Subject: SP-07-142, Ken Jacobson – 3-Lot Commercial Short Plat (1.85 Acres)
I-90, Exit 136 (Vantage/Huntzinger Road Interchange) Vicinity

We have reviewed the proposed plat, and have the following comments.

RE: Ken Jacobson Short Plat (SP-07-142)

TO: Mackenzie Moynihan, Community Development Services
FROM: Christina Wollman, Planner II *cw*
DATE: November 6, 2007
SUBJECT: Ken Jacobson Short Plat

KEN JACOBSON SHORT PLAT

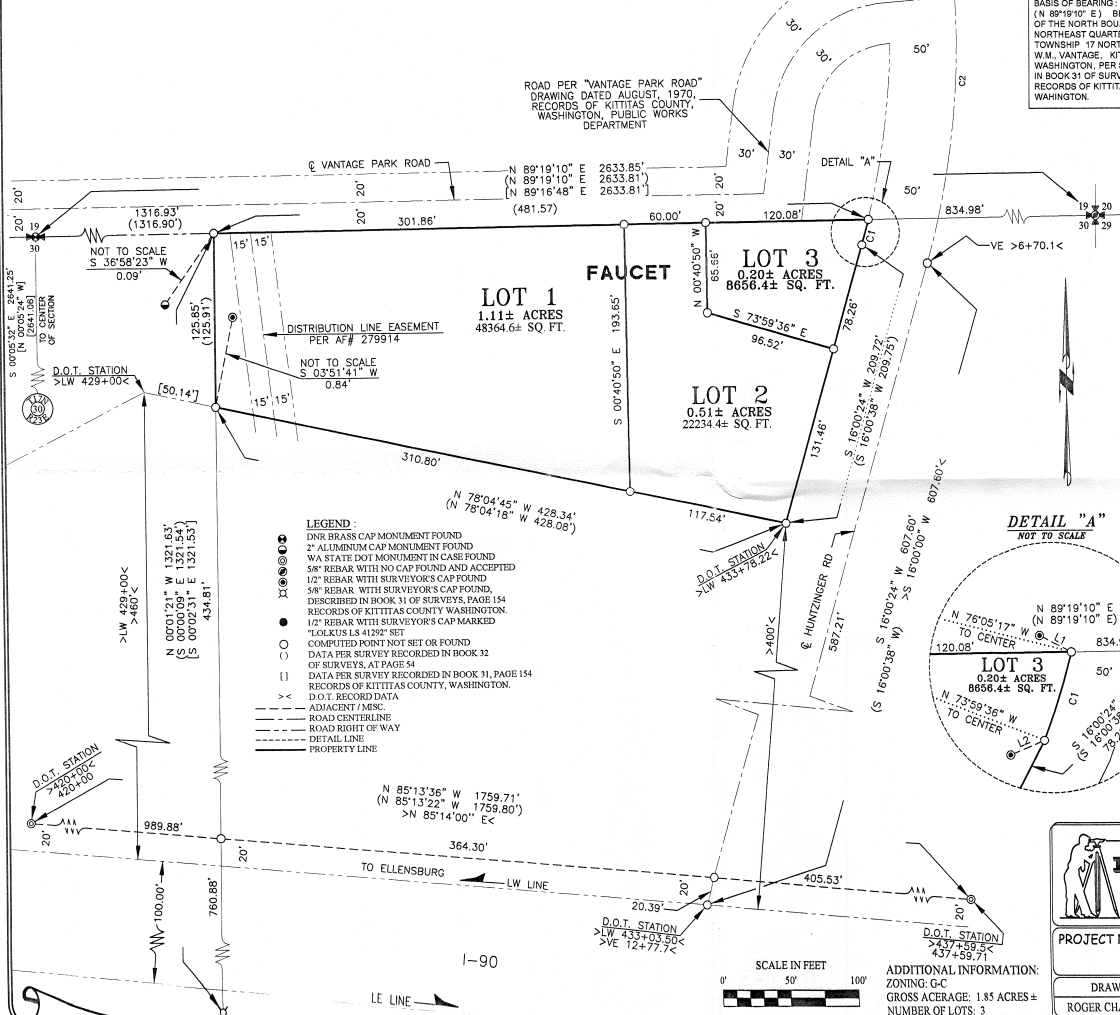
1. County Right-of-Way: One access to each lot will be allowed if 100' access spacing requirements can be met. Accesses must be delineated through the use of cement concrete traffic curbs (non-mountable) as specified by WSDOT Standard Plans F-10.12-00. The curbs shall be certified by a civil engineer licensed to practice in the State of Washington prior to receiving a building permit.

2. Access Permit: Accesses must meet the 100' spacing requirement. An approved access permit shall be required from the Department of Public Works prior to creating any new driveway access or performing work within the county road right of way.

3. Joint-Use Driveway: A joint-use access shall serve no more than two tax parcels. See Kittitas County Road Standards, 9/6/05 edition.
 - a. Access easements shall be a minimum of 20' wide. The roadway width shall have a minimum width of 12'.

- e. Any further subdivision or lots to be served by proposed access may result in further access requirements. See Kittitas County Road Standards.
- f. A public utility easement 10 feet in width is reserved along all lot lines. The 10 foot easement shall abut the exterior plat boundary and shall be divided 5 feet on each side of interior lot lines. Said easement shall also be used for irrigation.

KEN JACOBSON SHORT PLAT / SITE PLAN

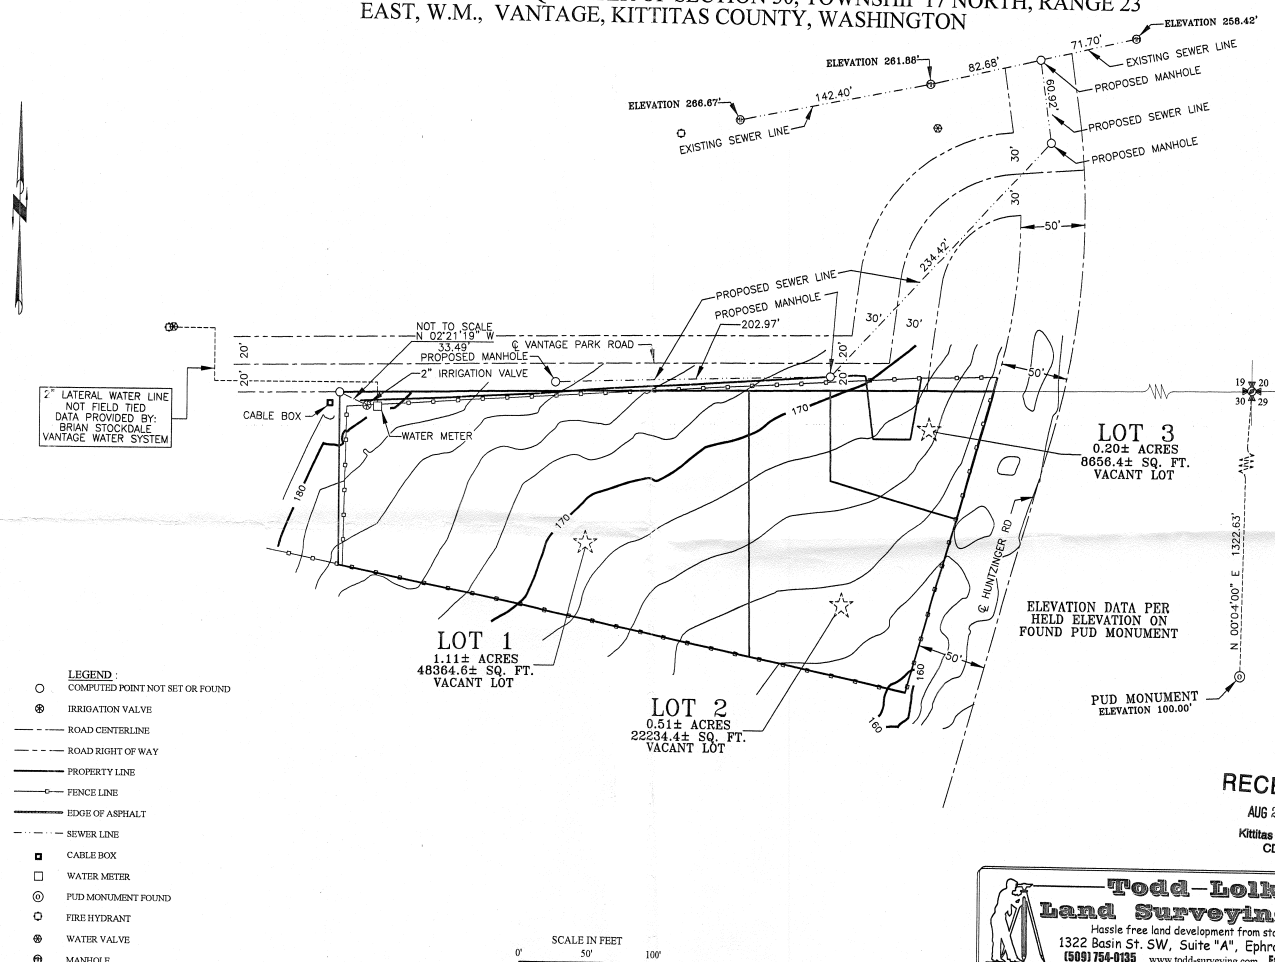
1. The plat area is adjacent to the westbound on-ramp of the Interstate 90 Vantage/Huntzinger Road interchange (Exit 136). I-90, including the ramps, is a fully-controlled limited access highway with a posted speed limit of 70 miles per hour. The limited access boundaries extend along Huntzinger Road (see attached right-of-way sheet). The crossover (Huntzinger Road) is unchannelized. Access to the property is via the Vantage Park county road. No direct access to I-90 or within the limited access boundaries along Huntzinger Road will be allowed.

2. Stormwater and surface runoff generated by this project must be retained and treated on site in accordance with regulating agencies' standards, and not be allowed to flow onto WSDOT rights-of-way.

3. Any proposed lighting should be directed down towards the site, and away from I-90.
4. Any outdoor advertising or motorist signing considered for this project will need to comply with state criteria. Please contact Rick Gifford of the WSDOT South Central Regional Office at (509) 577-1985 for specifics.
